**From:** Andrew Wood <Andrew.Wood@arun.gov.uk>  
**Sent:** 12 February 2020 09:53  
**To:** Planning.Responses <Planning.Responses@arun.gov.uk>  
**Subject:** FW: A/140/19/NMA FW: Angmering Link Footpath

**Subject:** A/140/19/NMA FW: Angmering Link Footpath

**Subject:** Angmering Link Footpath

Please find attached revised footpath design for the site between Cresswell Park and Quiet Waters, Angmering.

REV. No.	DATE	DESCRIPTION	INITIALS
Client			
Project			
Angmering			
Footpath Link

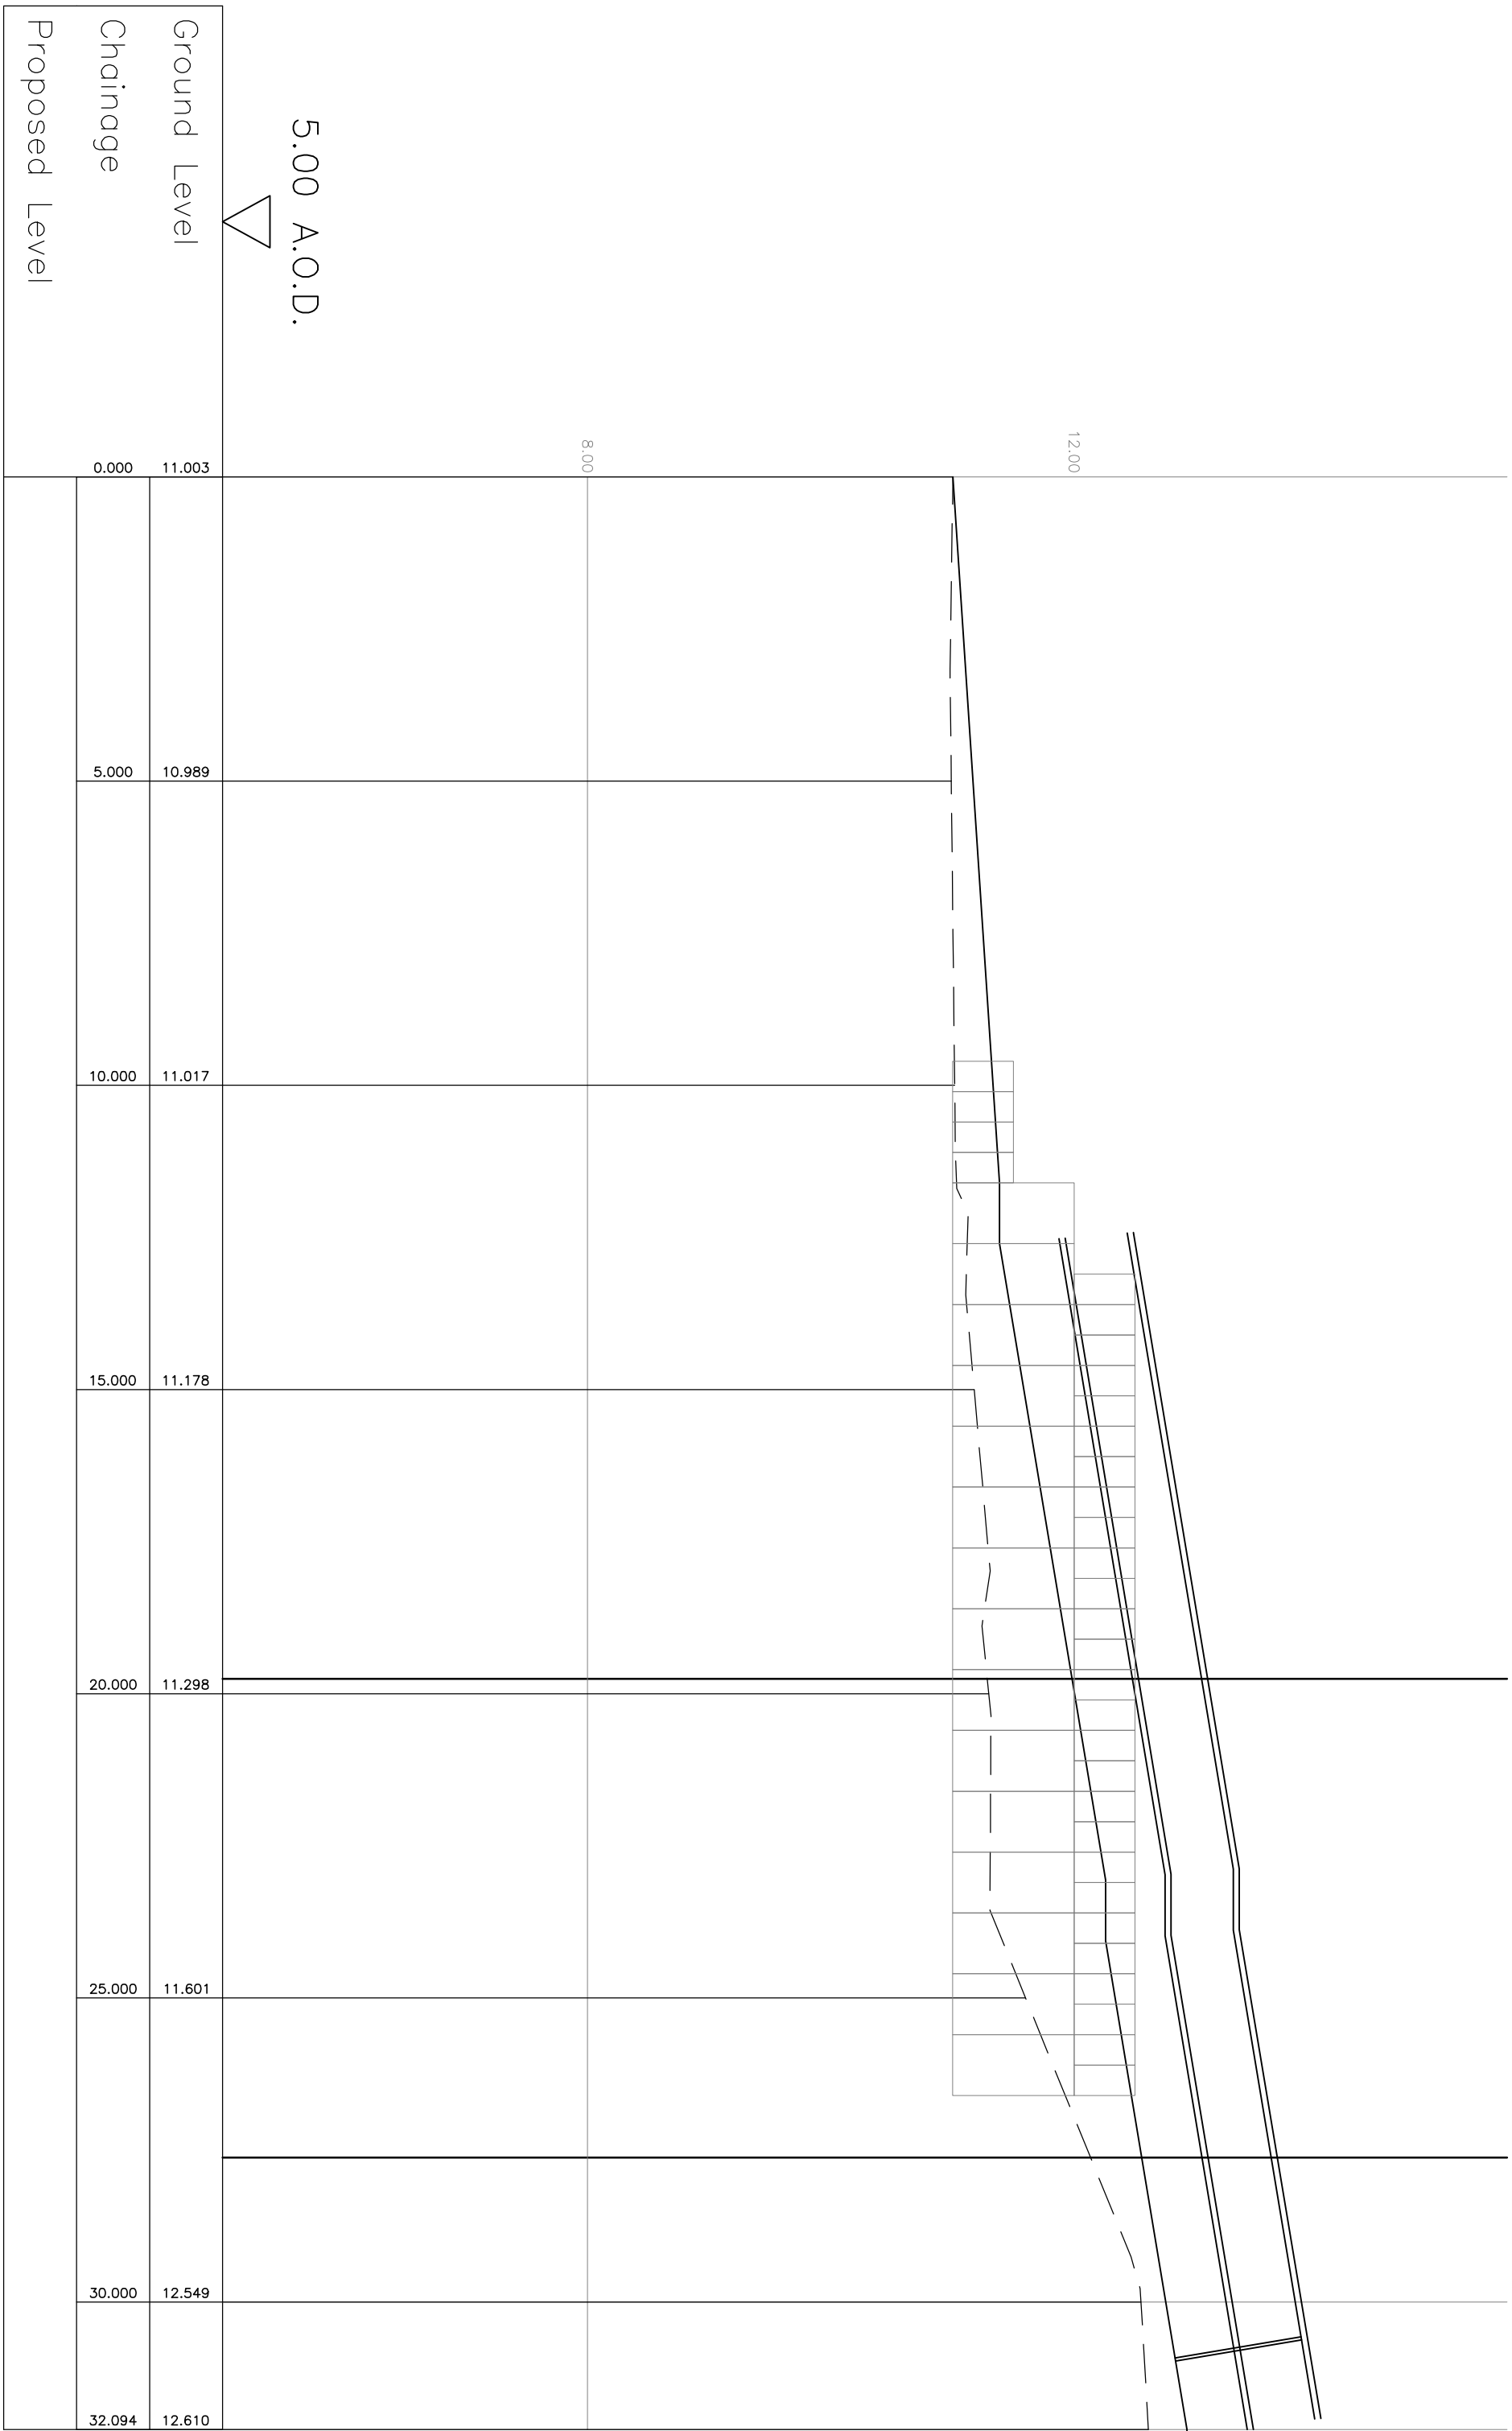
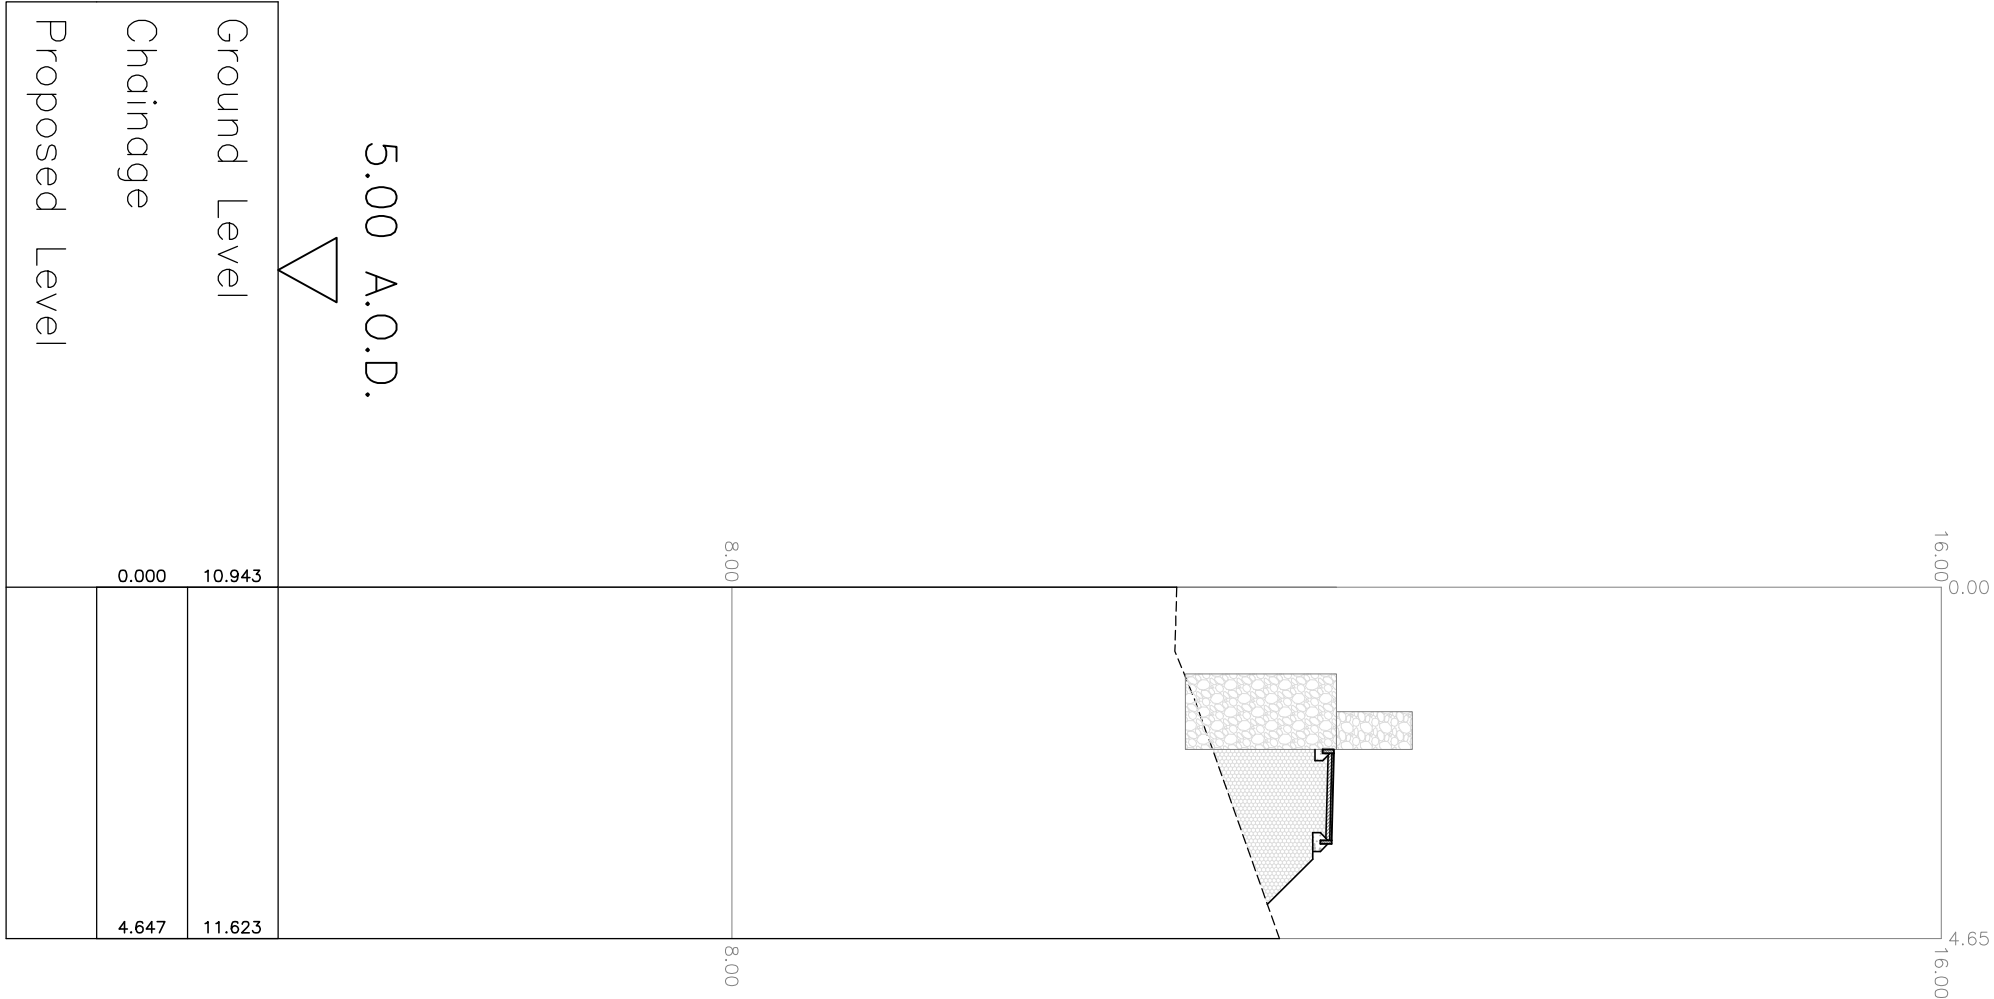
Following your email of Thu 06/02/2020 15:45 Please see amended plans for footpath link.

Is this acceptable?

Andrew,  
Plan is the minimum acceptable width as such no objection is raised to the NMA.
